Ribble Valley Borough Council  
Housing & Development Control

Application no: **3/2022/0047**

Address: **Cuthbert Hill Farm Garstang Road Chipping Lancashire**

Proposal: **New access to the highway (following the blocking off of existing) and extension to existing agricultural building.**

SITE PLAN SCALE 1:500

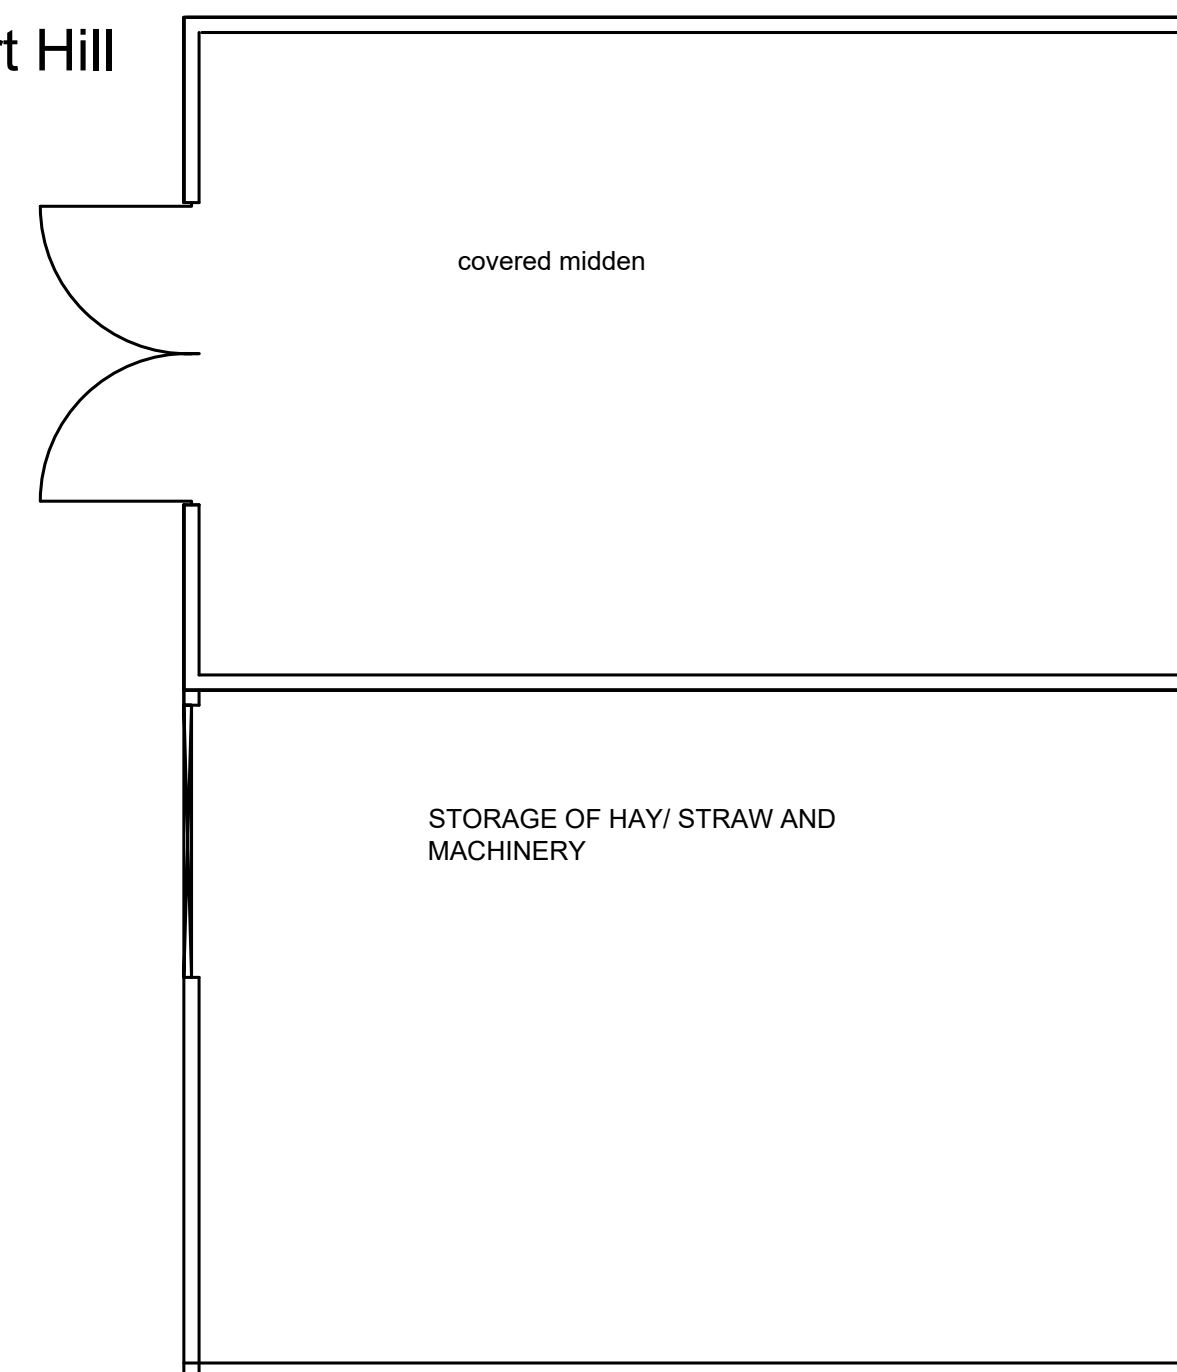
However, should the application be permitted, the LHA inform the Applicant that the access should be reduced in length to approximately 2m to enable the access to be used for the Public Footpath and to prevent vehicles from using the access.

In any case, the LHA have reviewed ML drawing number SP/EH/4010 titled "Building Plans" and are satisfied that the access width and the setback distance of the gate complies with the LHAs guidance.

However, the LHA are aware that a welfare unit was approved under application reference 3/2021/1075 and was located adjacent to the farmhouse. This unit, which will be adjacent to the access track into and out of the site, is not shown on any of the supporting documents. Therefore, to ensure that the access track into and out of the site is suitable, the LHA require a revised drawing to be submitted showing the approved welfare unit.

PROPOSE SITE PLAN SCALE 1:500

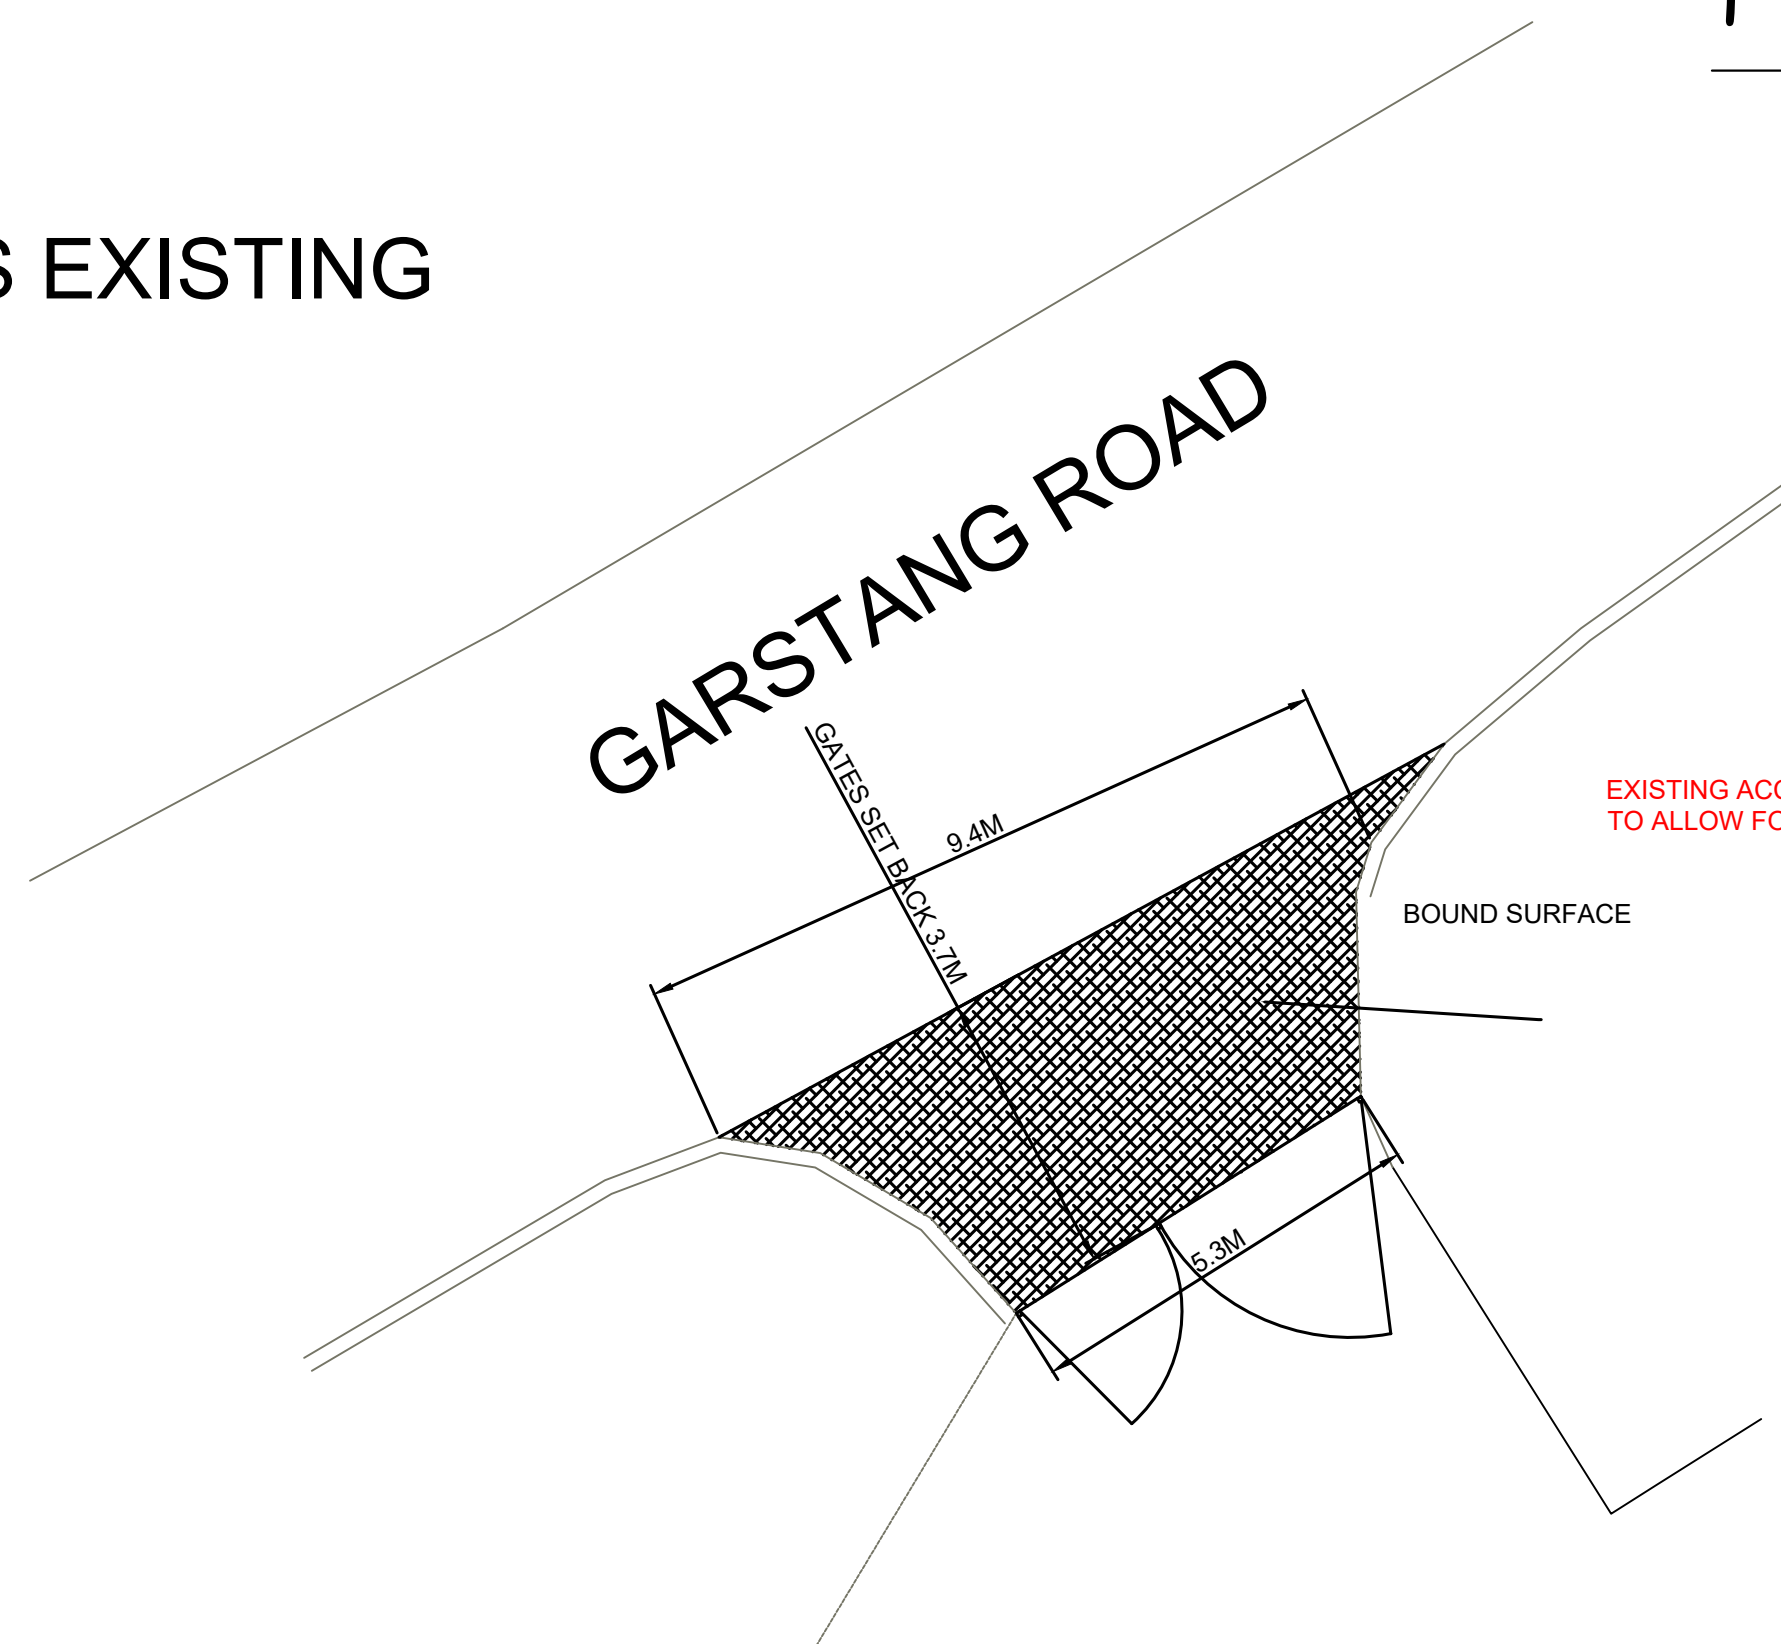
The LHA have also reviewed ML drawing number SP/EH/4026 titled "Visibility Splays" and understands that the drawing shows that the access can provide visibility splays of 2.4m x 215m to the right of the access. This complies with the LHAs guidance for a 60mph road.

However, the visibility splay to the left of the access is not scaled and, in any case, the LHA are unable to accept the visibility splays currently provided. This is because the visibility splays are not drawn from a setback distance of 2.4m from the public highway. The splays into the carriageway are not provided via a single line denoting the splay. Instead, they are provided with a hatched line in both directions with the thickness of the line being approximately 1.2m. Therefore, it is difficult for the LHA to assess clearly the sites visibility.

As a result, the LHA require a revised visibility splay drawing to be submitted to show the vehicular visibility the site can provide.
